REF: 15 SARDEN BROOK COURT. (APP 3/2024/0329)

IN RESPONSE TO YOUR EMAIL 9 AUGUST 2024

Drawing no 5007/a

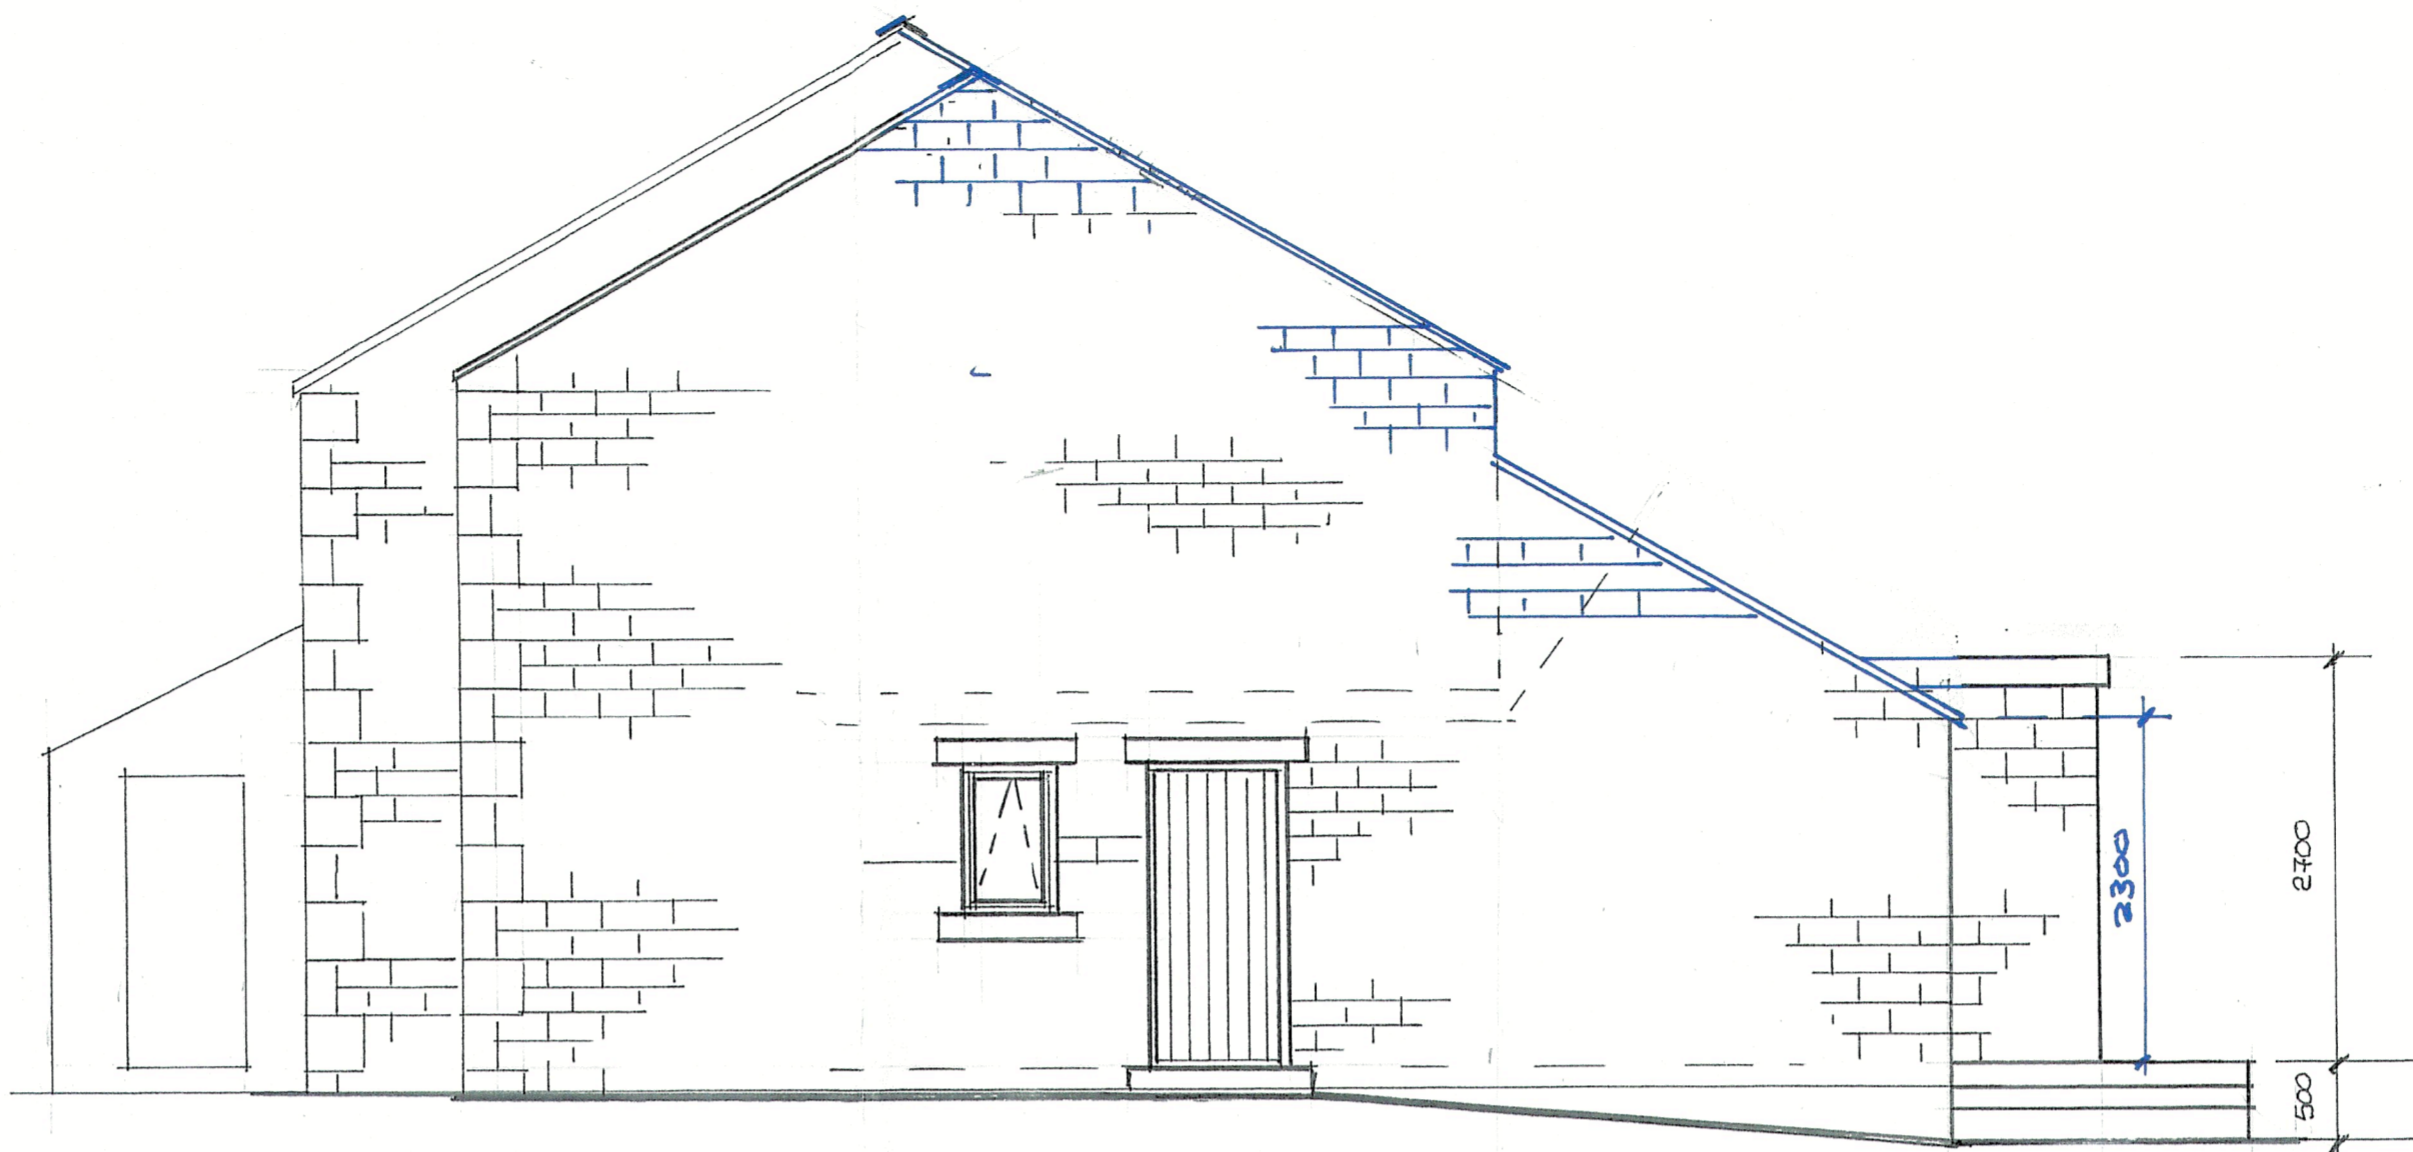
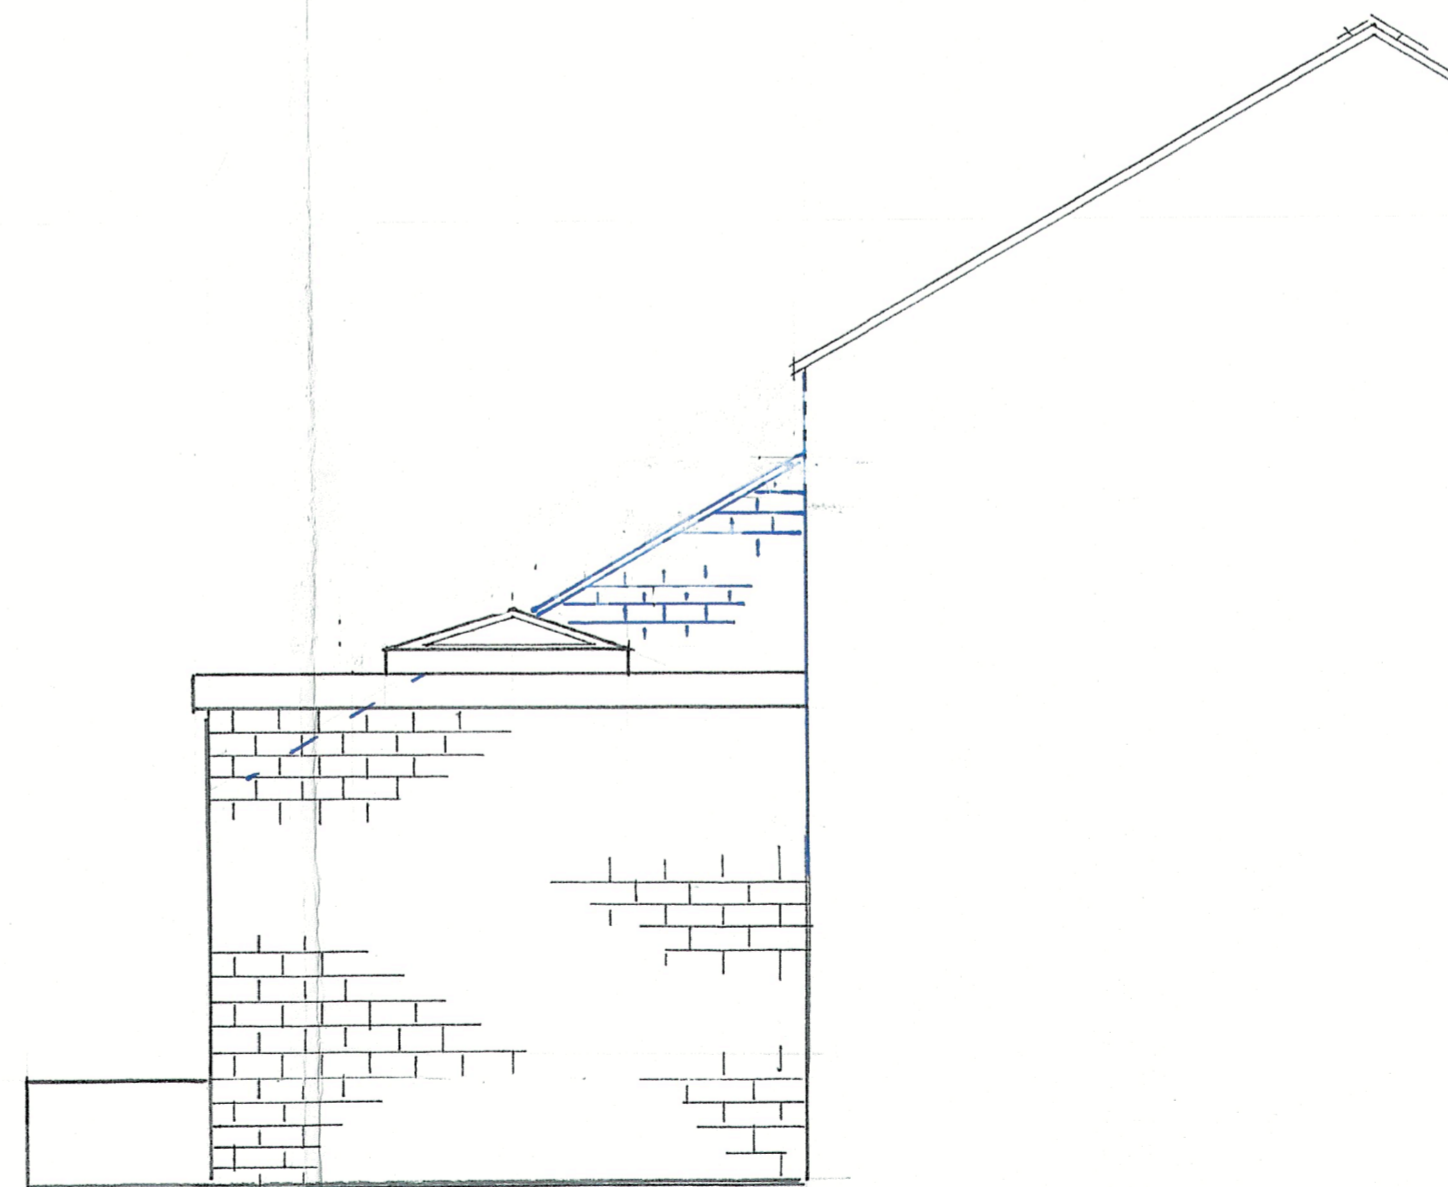
A.P. STATES HIGH LEVEL OF VISIBILITY FROM THE PUBLIC? SOUTH-WEST OF THE APPLICATION SITE IS THE PRIVATE CAR-PARK EXCLUSIVELY FOR PRIVATE USE. THERE ARE NO VISUAL POINTS OF VISIBILITY LET ALONE HUNDREDS?

We have a (taken) the plan showing a 'split level' roof as suggested by A.P. (this suggestion should have been raised) within the initial consultation period.) rather than a (mind) set to refuse with unreliable statements.

site plan
(1:25)

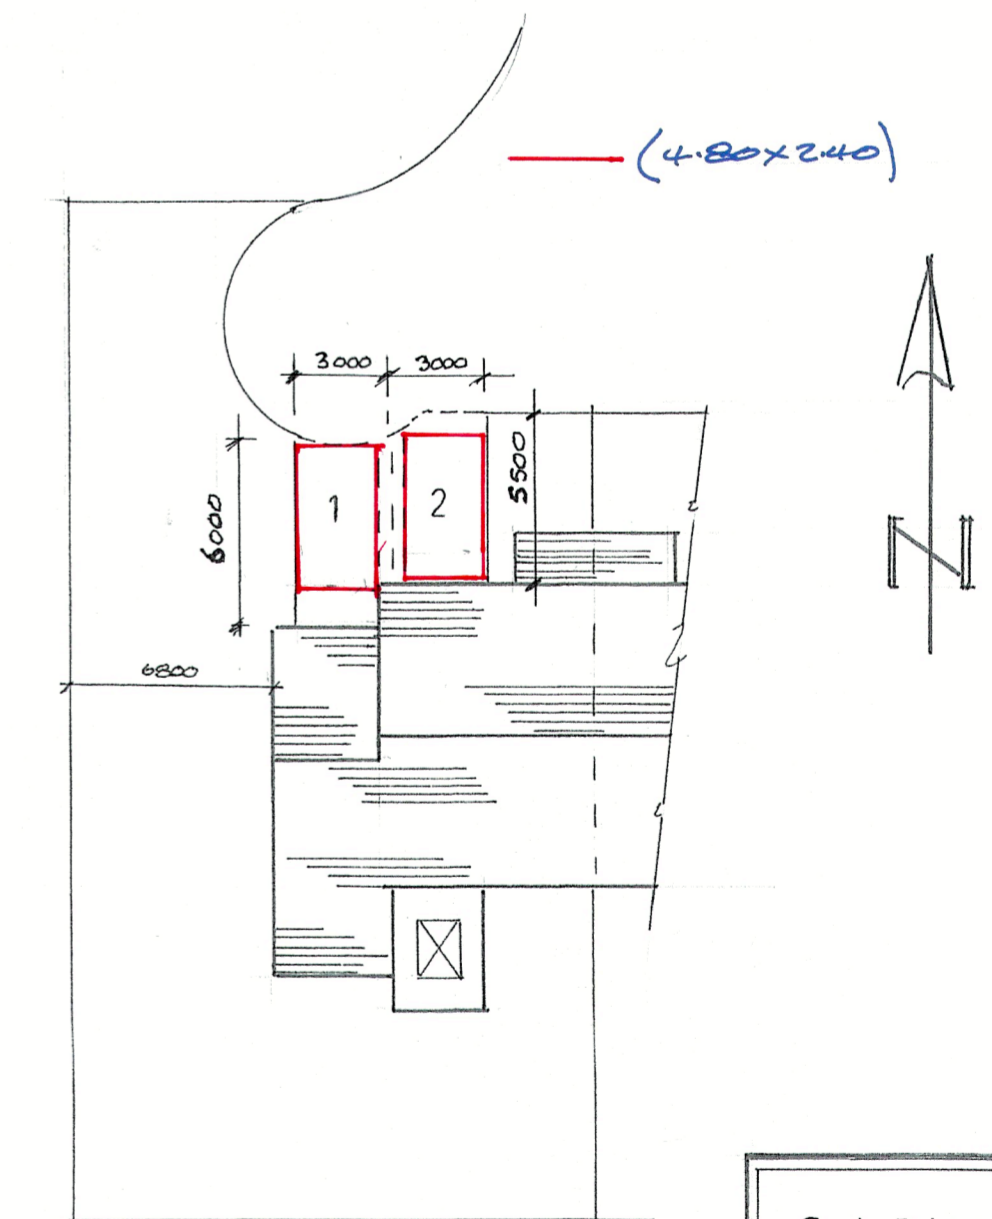
CONTRARY TO YOUR COMMENTS, CONFLICTS WITH A.P. STATEMENT AND MY CONVERSATION WITH K.H. A.P. CONCERN (STATEMENT) PRELAYS THE LOSS OF APPROXIMATELY HALF OF THE DRIVEWAY LEAVING THE DRIVEWAY WITH ONLY ONE HALF OFF ROAD PARKING. 'HOWEVER' THE PLAN CLEARLY SHOWS 2 SPACES. THE BLOCK PLAN IS TO THE SCALE AS STATED. FOR THE AVOIDANCE OF DOUBT, WE HAVE DIMINISHED THE PLAN.

MY CONVERSATION WITH K.H. DIFFERS FROM YOURS. PLAN NO 5007 SHOWING CAR-SPACES WERE NOT PRESENTED TO HIGHWAY 0 WITHIN THE CONSULTATION PERIOD. THEREFORE CONCERN COULD NOT BE RAISED OTHER THAN CONCERNS/ADVICE TAKEN FROM A.P. REITERATING I WILL CLARIFY WITH K.H. TO AVOID ANY FURTHER MISUNDERSTANDING.
